NSW RURAL FIRE SERVICE

Your Ref: MP 05_0038 MOD 1
Our Ref: DA-2006-00989-S4.55-1

**Major Projects Application
Modification – Rural Residential Subdivision
Lot 156 DP 753202 & Lots 53 & 54 DP 836998; 6920 The Bucketts Way Taree South**

PROPOSED SUBDIVISION LAYOUT OVERALL STAGE PLAN

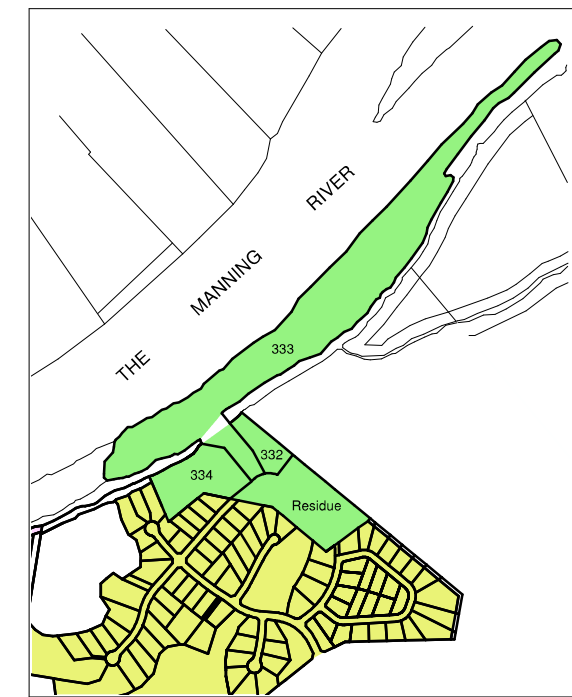
The MOD application seeks to modify the original layout by way of road design and lot layout and staging release time frame.

The NSW RFS cannot support the Modification application in its current form. The modification application and supporting documentation do not adequately justify how the proposed road layout for stage 1 will provide safe access for fire fighters, and residents, when the main singular public access road will traverse a riparian reserve corridor. It is also assumed that this riparian reserve will also be revegetated with koala vegetation species, further adding to the un-managed bush fire threat therefore a potential access constraint into the norther component of the estate.

The NSW RFS would require a secondary public access provision, traversing the riparian corridor, to ensure fire fighters and residents have an alternative road access (stage 1) during immediate bush fire threats to the residential estate.
